REQUEST

Current Zoning: R-17MF LWPA (multifamily residential, Lake Wylie Protected Area)
Proposed Zoning: B-2(CD) LWPA (general business, conditional, Lake Wylie Protected Area)

Approximately 3.08 acres located on the west side of Sam Wilson Road, north of Performance Road.

The petition proposes to redevelop the site to replace one single family home with uses permitted in the B-2 district.

**RZ-1**

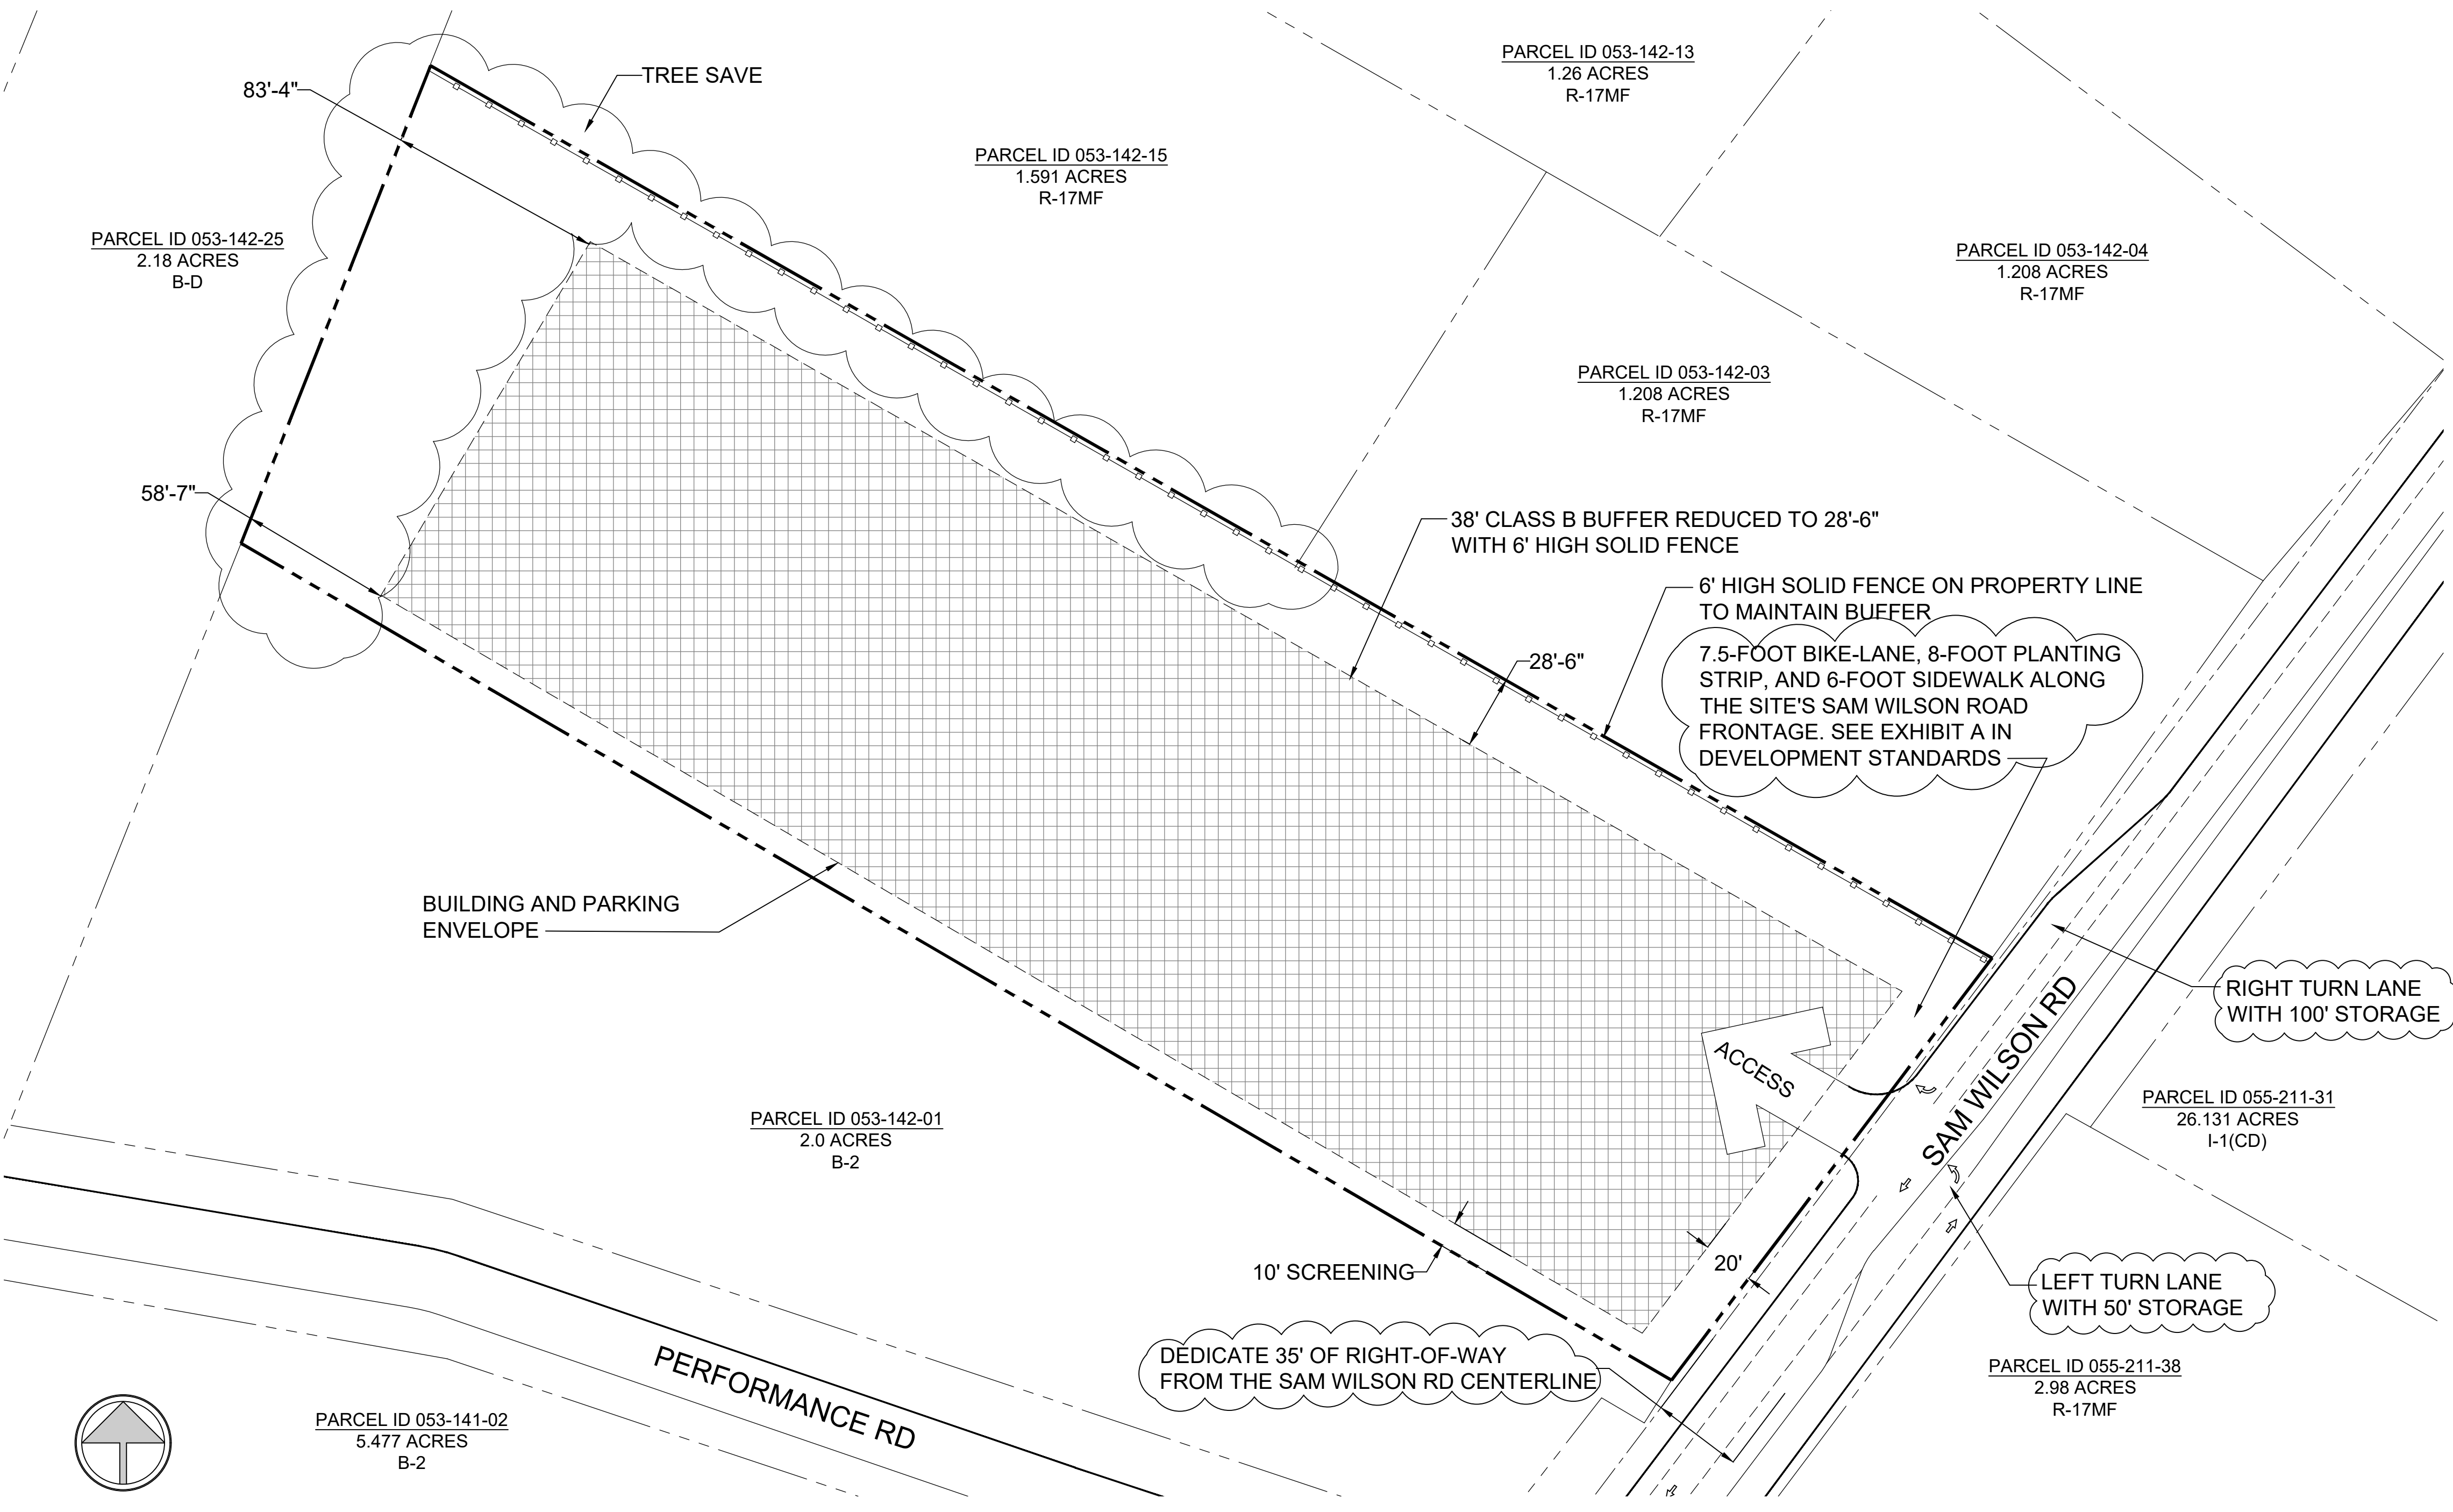
3. ~~Label and dimension each item from the existing center line of Sam Wilson Road.~~ **Update as a result of 12-29-2020 Site Plan:** Please label and dimension these items from the existing centerline of Sam Wilson. The right turn lane affects the dimensions shown in Exhibit A (included in the site plan), therefore, the dimensions need to be clearly identified to ensure the infrastructure is constructed in the correct location. **Addressed**
4. ~~Revise the site plan and conditional note(s) to include the construction of the cross section, as noted in the Catawba Area Plan, along the site's frontage on Sam Wilson Road. The bike lane, back of curb, planting strip, and sidewalk need to be labeled and dimensioned from the center line of Sam Wilson Road.~~ **Addressed**
